KITTTITAS COUNTY COMMUNITY DEVELOPMENT SERVICES

February 10, 2009

RE: Sky Sweeper Short Plat (SP-07-00153)

The Kittitas County Community Development Services Department has determined that the Sky Sweeper Short Plat (SP-07-00153) is a complete application and hereby grants *conditional preliminary approval* subject to the following conditions:

SKY SWEEPER SHORT PLAT
 PART OF SECTION 36, T. 18 N., R. 17 E., W.M.
 KITITAS COUNTY, WASHINGTON

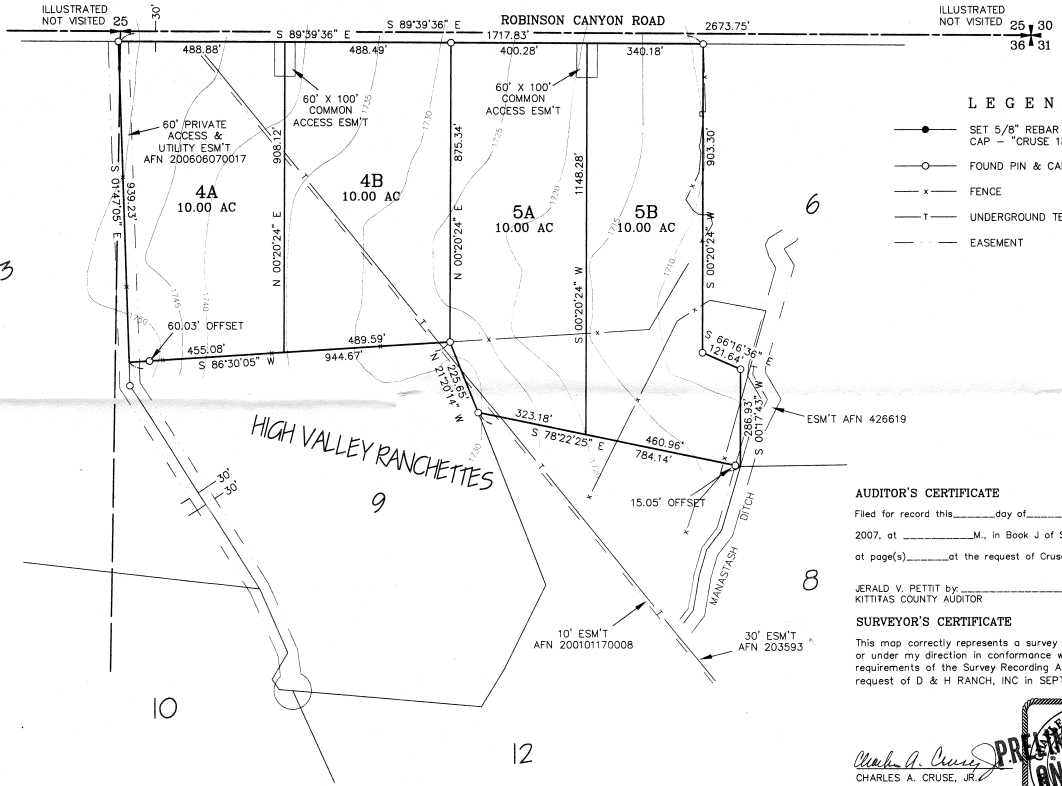
1. Both sheets of the final mylars shall reflect short plat number SP-07-00153 and an accurate legal description shall be shown on the face of the final plat.

2. Full year's taxes must be paid on all tax parcel numbers per requirement of the Kittitas County Treasurer's Office.
3. The following plat notes shall be recorded on the final mylar drawings:

- All development must comply with International Fire Code.
 - The subject property is within or near designated natural resource land of long-term commercial significance on which a variety of commercial activities may occur that are not compatible with residential development for certain periods of limited duration. Commercial natural resource activities performed in accordance with county, state and federal laws are not subject to legal action as public nuisances. (RCW 7.48.305)

- The approval of this division of land includes no guarantee that there is a legal right to withdraw groundwater within the land division. The approval of this division of land provides no guarantee that use of water under the ground water exemption (RCW 90.44.050) for this plat or any portion thereof will not be subject to curtailment by the Department of Ecology or a court of law.

- The Sky Sweeper Preliminary Plat No. SP-08-00032 currently has 5000 gallons of water per day for all domestic uses from the domestic well use exemption. According to WAC 173-539A, each lot of the Sky Sweeper Plat is allowed no more than 5000 gallons per day per lot.

- Kittitas County will not accept private roads for maintenance as public streets or roads until such streets or roads are brought into conformance with current County Road Standards. This requirement will include the hard surface paving of any street or road surfaced originally with gravel.
